CITY OF PORTLAND BUILDING PERMIT

Benjamin Wallace - Allagash Brewery - 50 Industrial Way - permit 2012-09-4996-ALTCOMM

From: Benjamin Wallace
To: Jeanie Bourke
Date: 10/29/2012 1:35 PM
Subject: Allagash Brewery - 50 Industrial Way - permit 2012-09-4996-ALTCOMM
CC: Chris Pirone
Attachments: Benjamin Wallace.vcf

Hi Michael,
I have the Allagash permit and a few questions I need clarified.

FIRST FLOOR FACILITY CODE COMPLIANCE PLAN
SCALE: 1/16" = 1'-0"

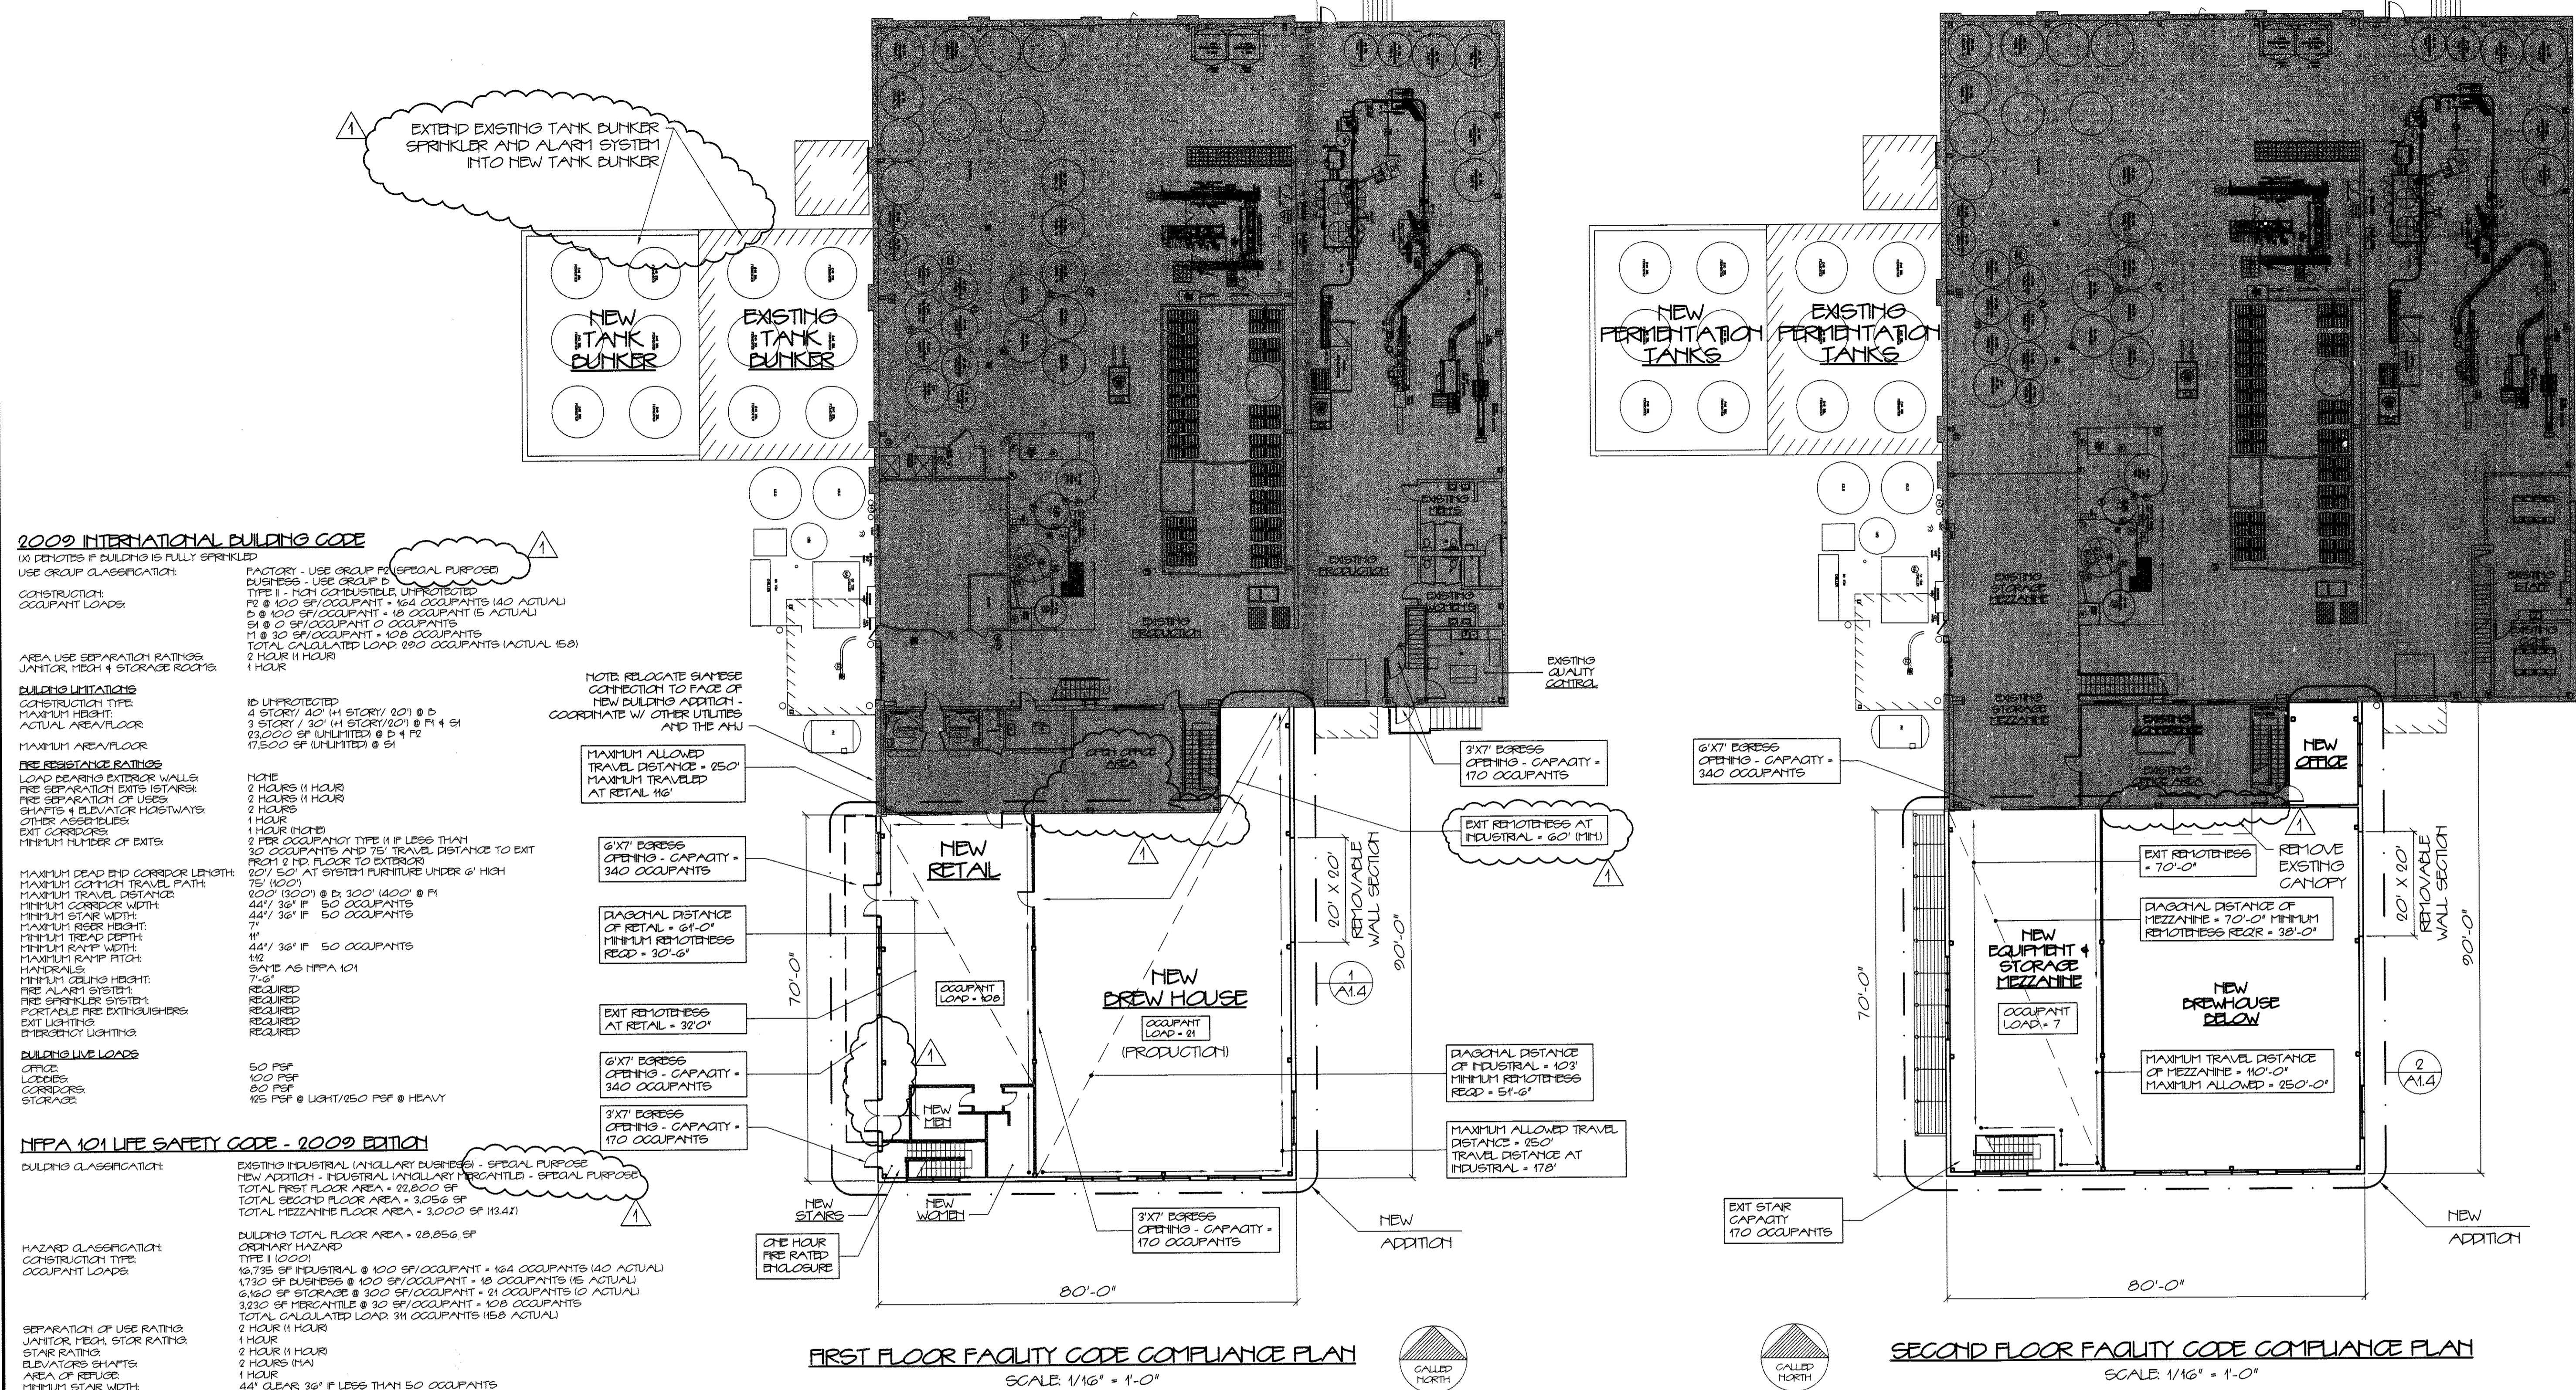
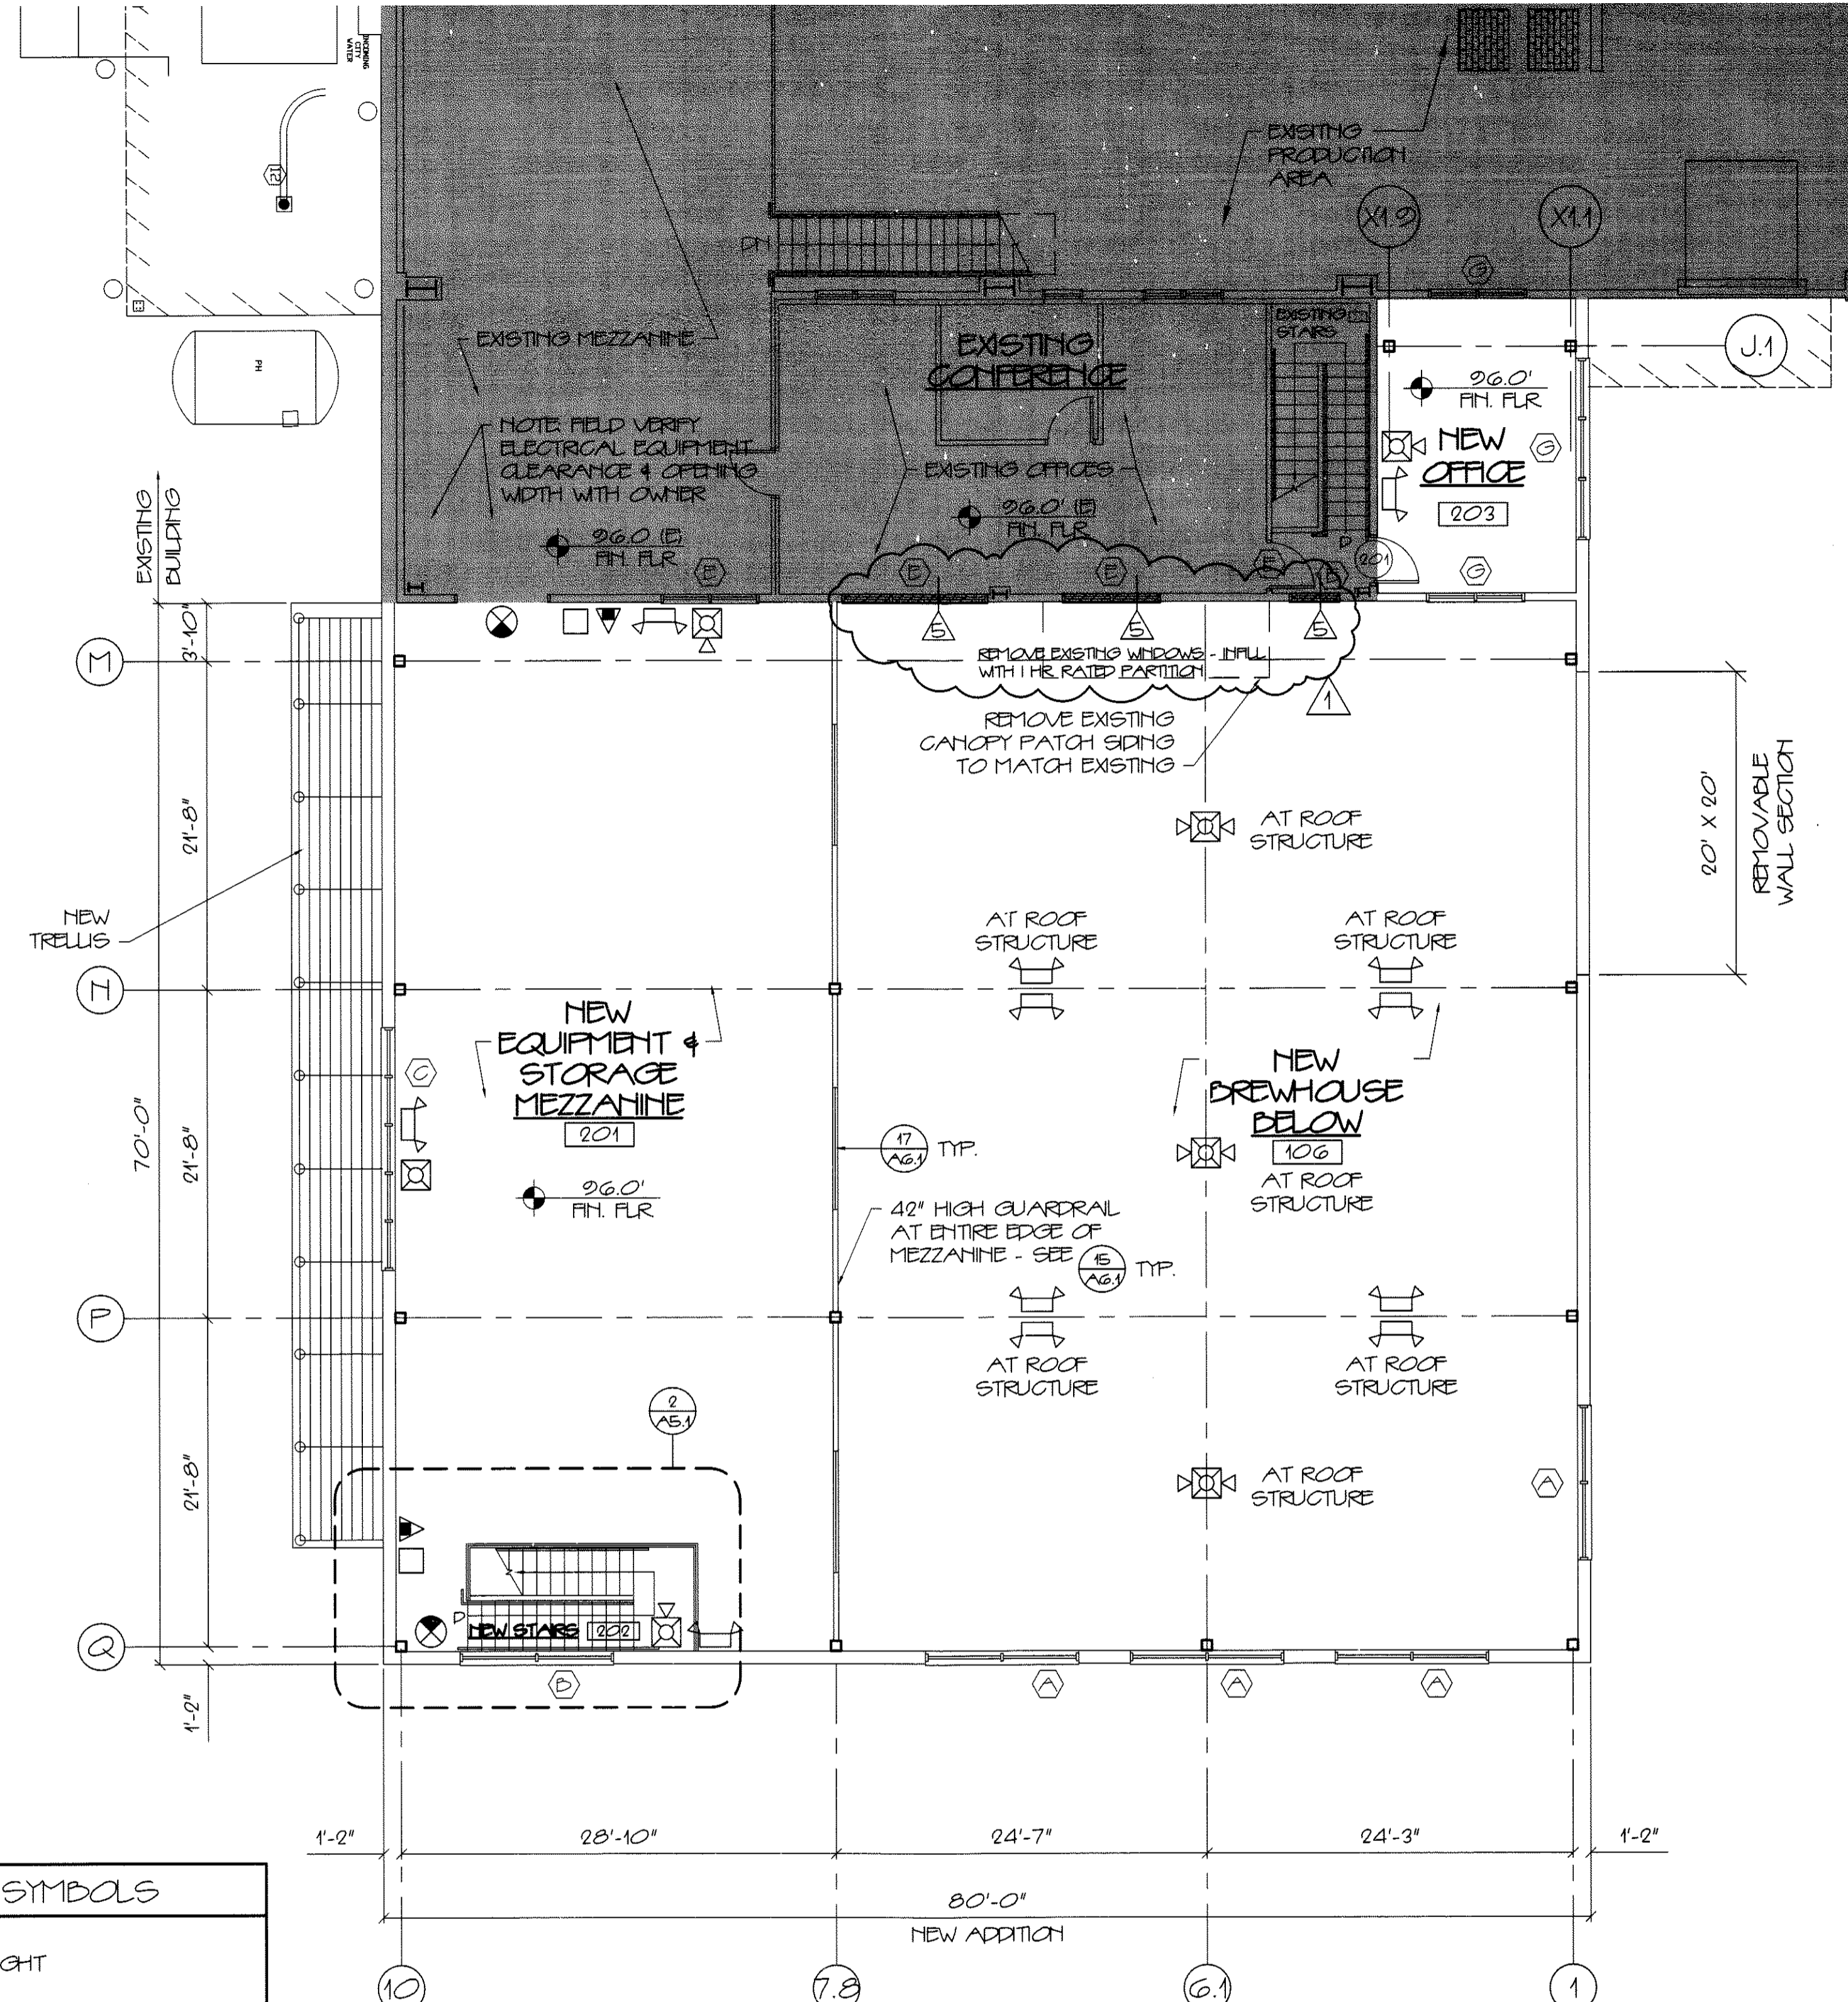
1. What is the occupancy sub-classification (NFPA 101:40.1.4.1)? I'm not sure this meets the intent of Special-Purpose Industrial so I think it's general purpose industrial.

2. The "mezzanine" does not appear to meet the area limitations of 101:8.6.9.2. Please explain if it is a mezzanine in accordance with the *Life Safety Code* or a story and how that affects your exits and separation of stories.

3. The plans show 1-hour wall separation between the new mercantile area and the Brew House but not from the "mezzanine" above or the production area in the existing building where the mercantile is currently located. The North wall of the new mercantile space was an existing exterior wall with windows and a door and is assumed to have no fire resistance rating. Please explain both.

4. The existing exit stair from the second floor office space currently discharges directly outside. The South and East exit stair walls are assumed to have no fire resistance rating. Please explain this and also how the single exit from the new office space is allowed to discharge through the level of exit discharge (Brew House) which might be considered a hazardous area. Please also consider 101:40.2.5.1 when explaining.

5. Door 108 is not listed on the door schedule. What is its fire resistance rating?
6. The Brew House does not have the required remoteness; 51'-6" as indicated on your plan. An overhead door can not be used as an exit door and the replacement door is not listed on the door schedule. Please explain.

7. The new stair from the mezzanine is not enclosed at the top as required by 101:7.2.2.5. Please explain.
8. Please explain if the fermentation tank bunkers are required to be protected by sprinklers under the scope of NFPA 13, *Standard for the Installation of Sprinkler Systems*, 2007 edition. It looks like they are covered by the building's roof and may have walls around them?
